**Application by RWE Renewables UK Solar and Storage Limited for an Order granting
Development Consent for the Tween Bridge Solar Farm**

Planning Inspectorate Reference Number: EN010148

Written Representation and Summary submitted on behalf of National Highways Limited

7/1, 7/2, 7/3, 7/4, 7/5, 7/6, 7/19, 7/23

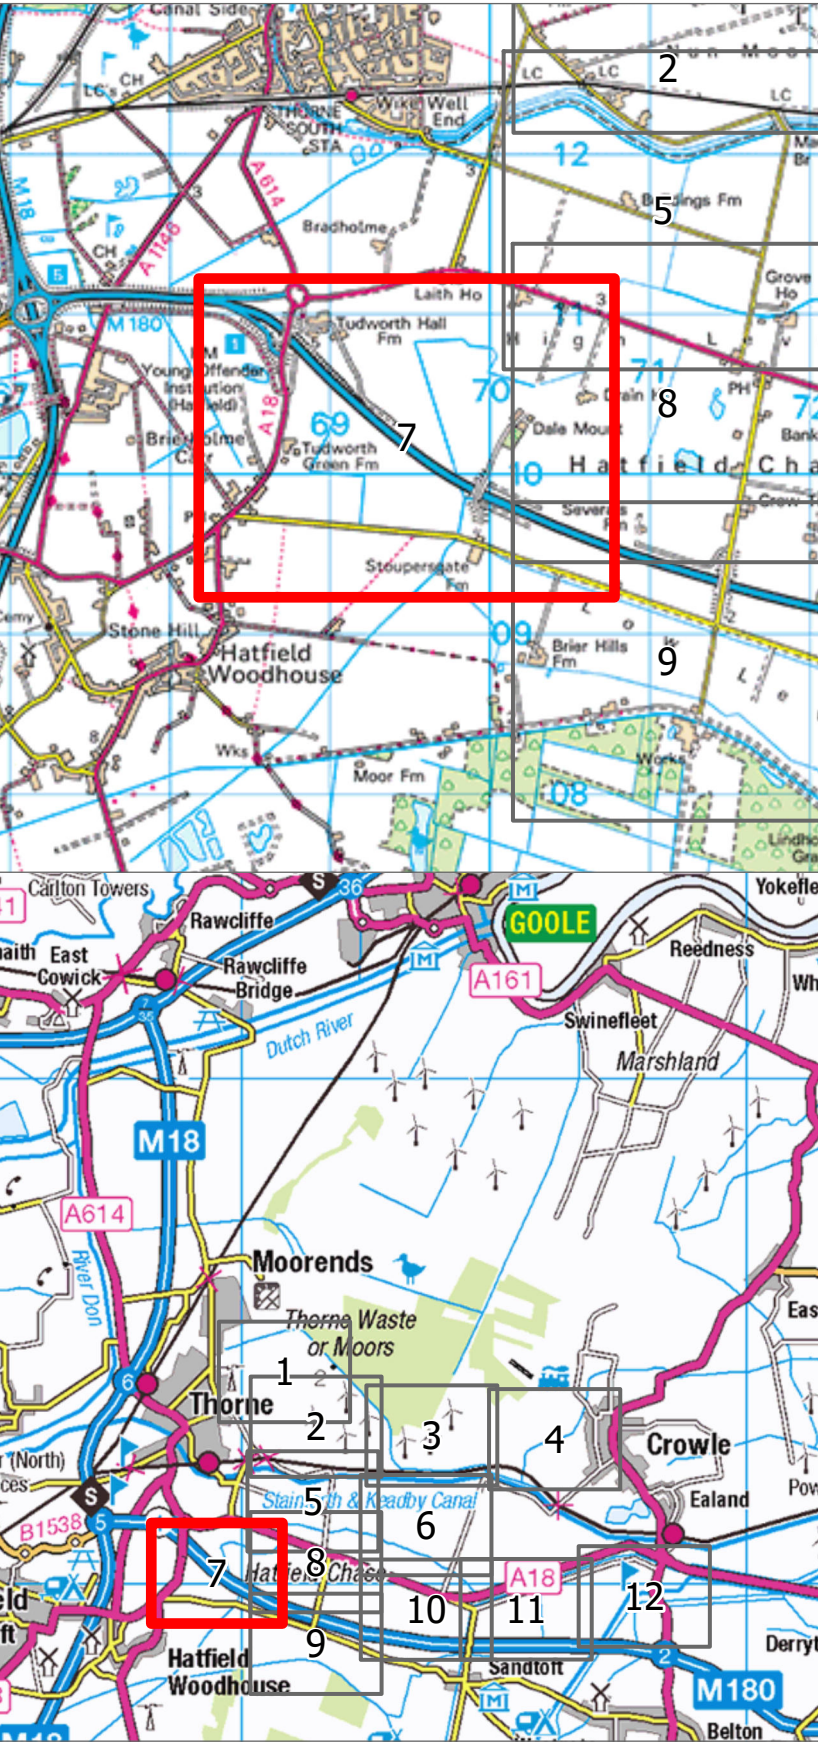
Plot	Nature of NH Interest	Acquisition Category	Works Proposed	Detriment to NH
7/7	Category 2	Permanent Acquisition and Temporary Possession	Work Nos. 1D, 2, 3 and 8	Although in third party ownership, this plot contains an NH drainage asset which will need to be protected. This can be achieved through the NH PPs.
7/13	Category 2	Permanent Acquisition and Temporary Possession	Work Nos. 1D, 2, 7 and 8	This plot is subject to restrictive covenants granting NH maintenance and repair rights. Any interference with these rights must be subject to NH's consent in accordance with the NH PPs.
7/14	Freeholder and occupier	Permanent Rights and Temporary Possession	Work Nos. 2 and 8	Although identified as freeholder in the Book of Reference, NH is not the registered owner and does not consider that this plot forms part of the SRN. NH currently benefits from an easement over this land. Any proposed extinguishment of this easement must be subject to NH's consent in accordance with the NH PPs.

7/17	Category 2	Permanent Acquisition and Temporary Possession	Work Nos. 1D, 2 and 8	This plot is subject to restrictive covenants granting NH maintenance and repair rights. Any interference with these rights must be subject to NH's consent in accordance with the NH PPs.
9/24	Freeholder and occupier	Permanent Rights and Temporary Possession	Work No. 2	NH understands that the works to this plot involve cabling beneath the SRN (within the subsoil beyond the vertical extent of the highway). Any works within this plot will need to be controlled by the NH PPs (refer to section 10 for further details). Any existing infrastructure will also need to be protected.
10/12	Freeholder	Permanent Rights and Temporary Possession	Work Nos. 2 and 8	This part of the highway has been de-trunked, meaning it has been vested in and is the responsibility of the local highway authority pursuant to section 265 of the

Plot no. on plan:
6/2, 6/6, 6/7, 6/13, 6/20, 6/21, 6/22, 6/25, 6/26, 8/17, 8/18, 9/25, 10/2, 10/4, 10/6, 10/9, 10/10, 10/12, 10/20, 10/22, 10/23, 10/24, 10/27, 10/30, 10/31, 10/32, 10/33, 10/34, 10/35, 10/37, 10/40, 10/47, 10/49, 10/50

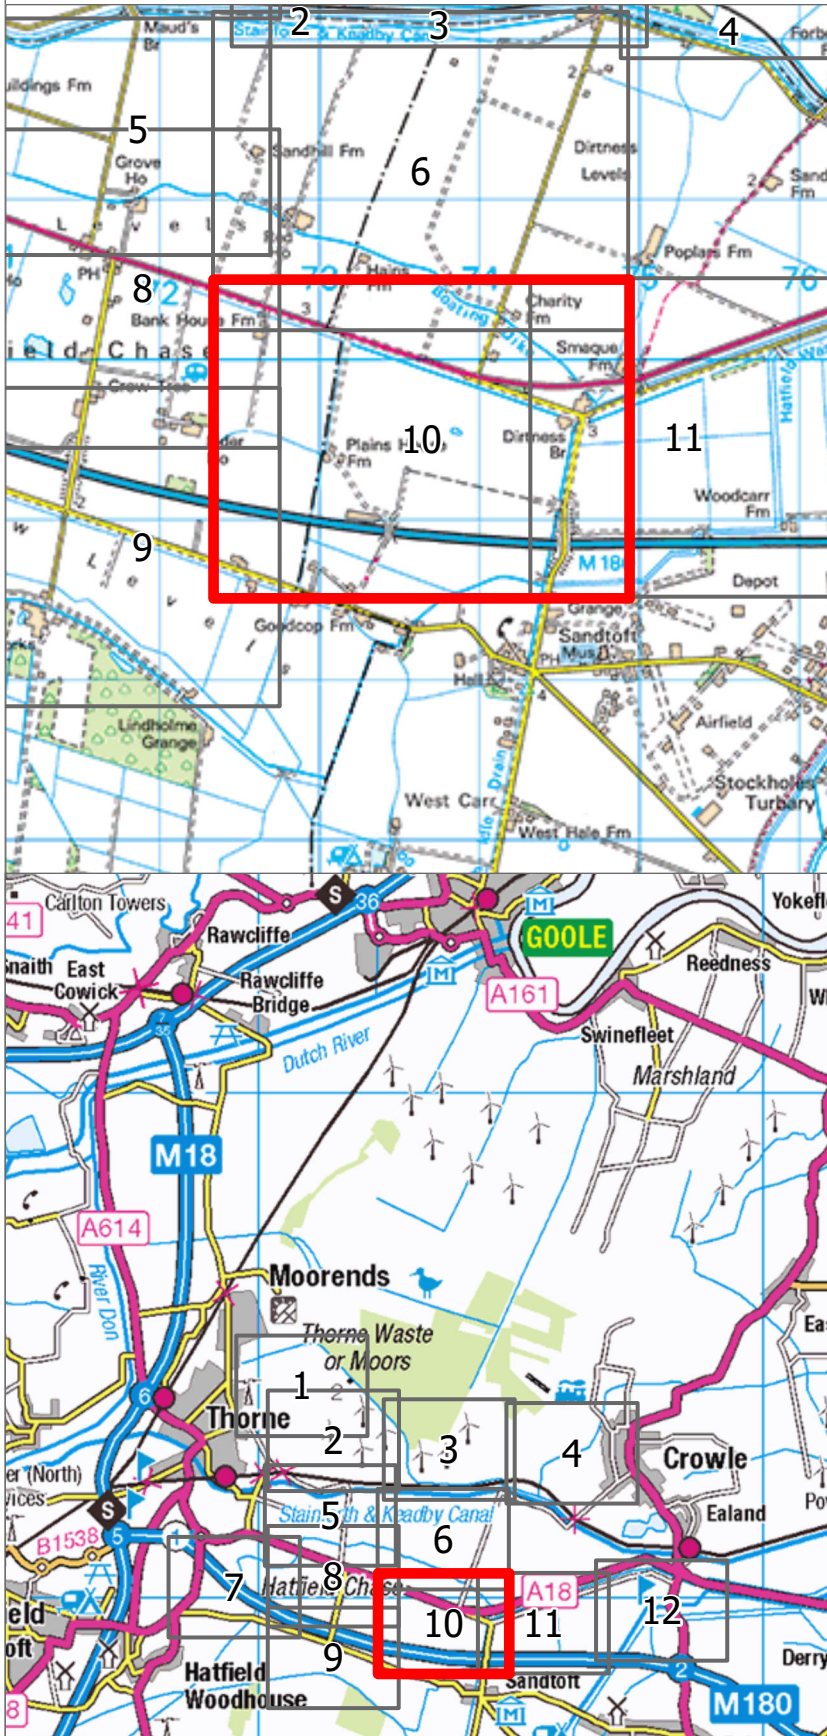
10/33	Freeholder	Permanent Rights and Temporary Possession	Work Nos. 2 and 8	NH is not aware of any interest it holds in this plot and therefore has no further comments or concerns at this stage.
10/35	Freeholder	Permanent Rights and Temporary Possession	Work Nos. 2 and 8	This plot was acquired by NH with the highway transferred to the local highway authority under a Side Roads Order and is part of the highway owned and maintainable by the local highway authority. NH retains title to the subsoil only pending the administrative task of transferring ownership which, unlike in the case of de-trunking, does not happen

automatically. NH therefore has no further concerns in respect of this plot at this stage. The Applicant should contact the local highway authority for non-subsoil works.
10/36	Freeholder	Permanent Rights and Temporary Possession	Work Nos. 2 and 8	This plot was acquired by NH with the highway transferred to the local highway authority under a Side Roads Order and is part of the highway owned and maintainable by the local highway authority. NH retains title to the subsoil only pending the administrative task of transferring ownership which, unlike in the case of de-trunking, does not happen automatically. NH therefore has no further concerns in respect of this plot at this stage. The Applicant should contact the local highway authority for non-subsoil works.
10/39	Freeholder	Highway Land Permanent Rights and Temporary Possession	Work Nos. 2 and 8	This plot was acquired by NH with the highway transferred to the local highway authority under a Side Roads Order and is part of the highway owned and maintainable by the local highway authority. NH retains title to the subsoil only pending the administrative task of transferring ownership which, unlike in the case of de-trunking, does not happen automatically. NH therefore has no further concerns in respect of this plot at this stage. The Applicant should contact the local highway authority for non-subsoil works.

Plot no. on plan:
11/21, 11/25, 12/3, 12/4, 12/5, 12/6, 12/7, 12/8, 12/9, 12/10, 12/11, 12/12, 12/13, 12/15

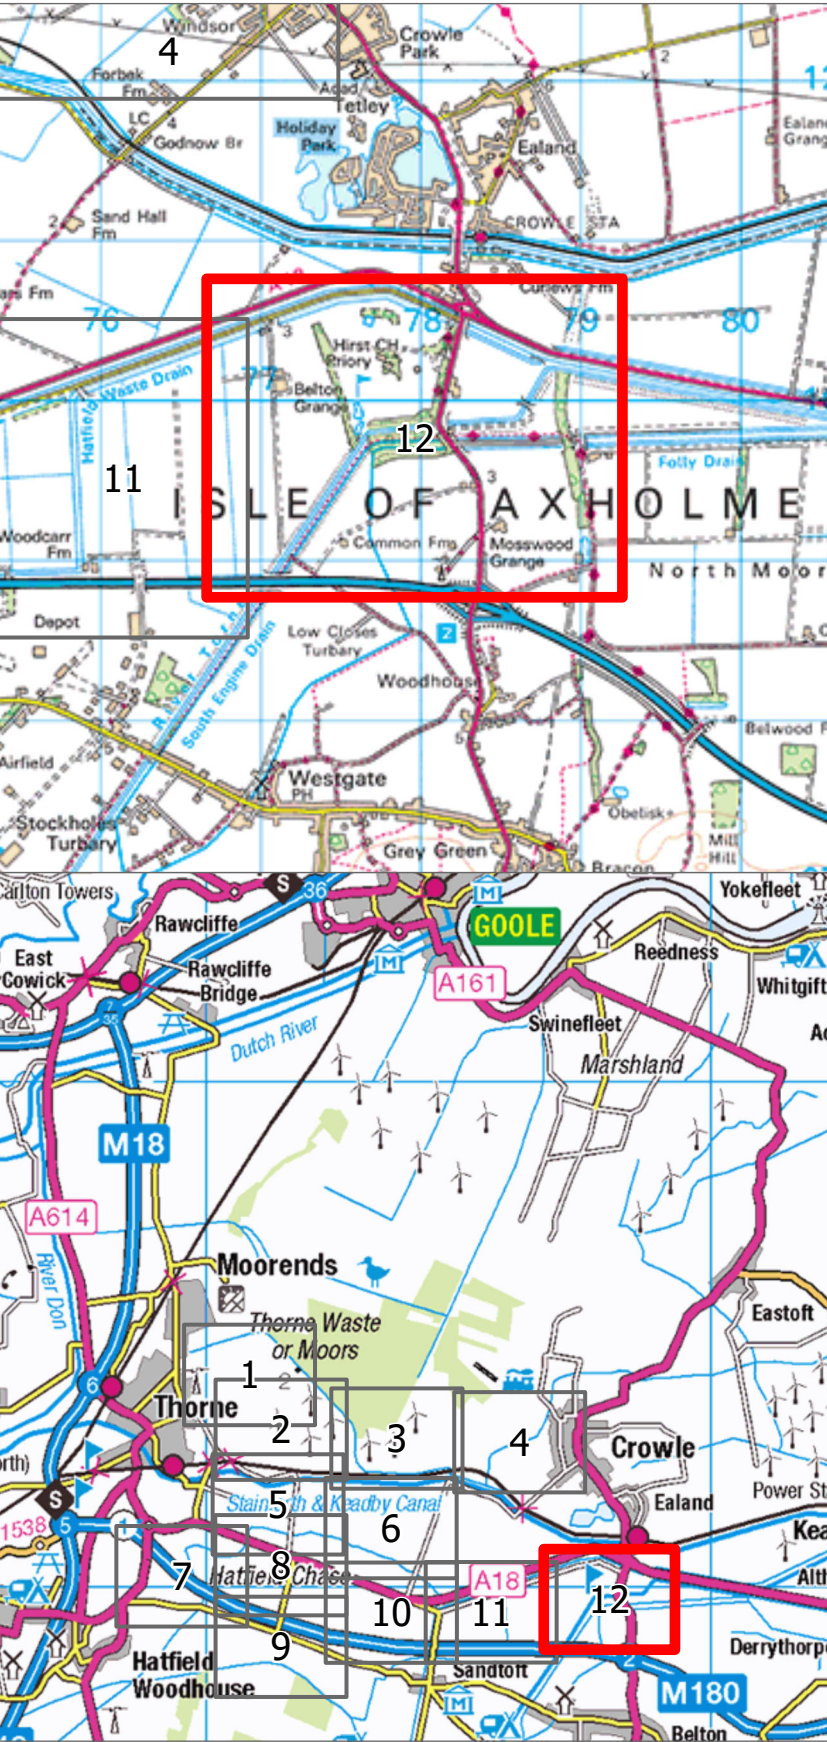
Temporary Possession		must be subject to NH's consent in accordance with the NH PPs.
11/25	Freeholder	Permanent Rights and Temporary Possession	Work Nos. 2 and 8	NH understands that the works to this plot could involve cabling beneath the SRN. Any works within this plot will need to be controlled by the NH PPs (refer to section 10 for further details). Any existing infrastructure will also need to be protected. NH further understands that the Applicant may seek to rely on highway drainage apparatus for outfall from the Authorised Development in this plot. This cannot be accepted – see section 8 below.
11/26	Category 2	Permanent Acquisition and Temporary Possession	Work Nos. 2 and 8	This plot is subject to rights in favour of NH. Any interference with these rights must be subject to NH's consent in accordance with the NH PPs.
12/6	Category 2	Permanent Rights and Temporary Possession	Work Nos. 2 and 8	This plot is subject to rights in favour of NH. Any interference with these rights must be subject to NH's consent in accordance with the NH PPs.
